75 Highfield Road.

Application GR/215/18/PL.

I wish to record my objection to the proposal to build 6 flats on this small site.

Site Plan (Proposed) 1:200

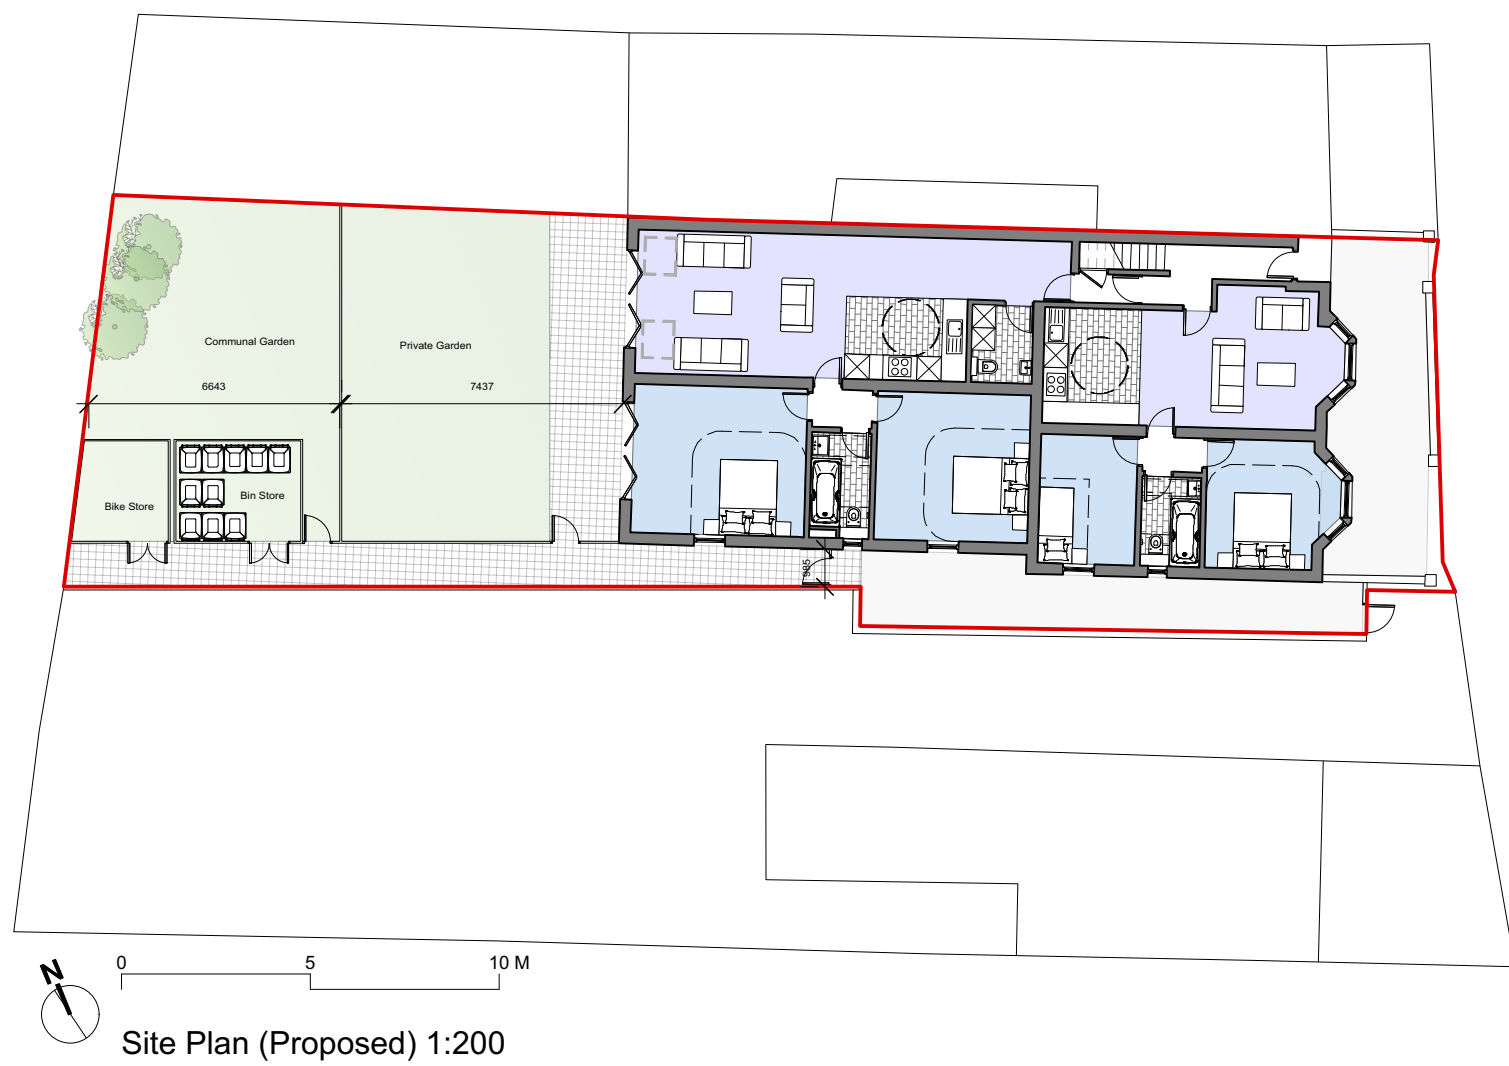
The loss of 1 parking space off road and the addition of a potential 12 cars to be parked on an already over crowded road used as a short cut between the roundabout and Hounslow Way should not be considered.
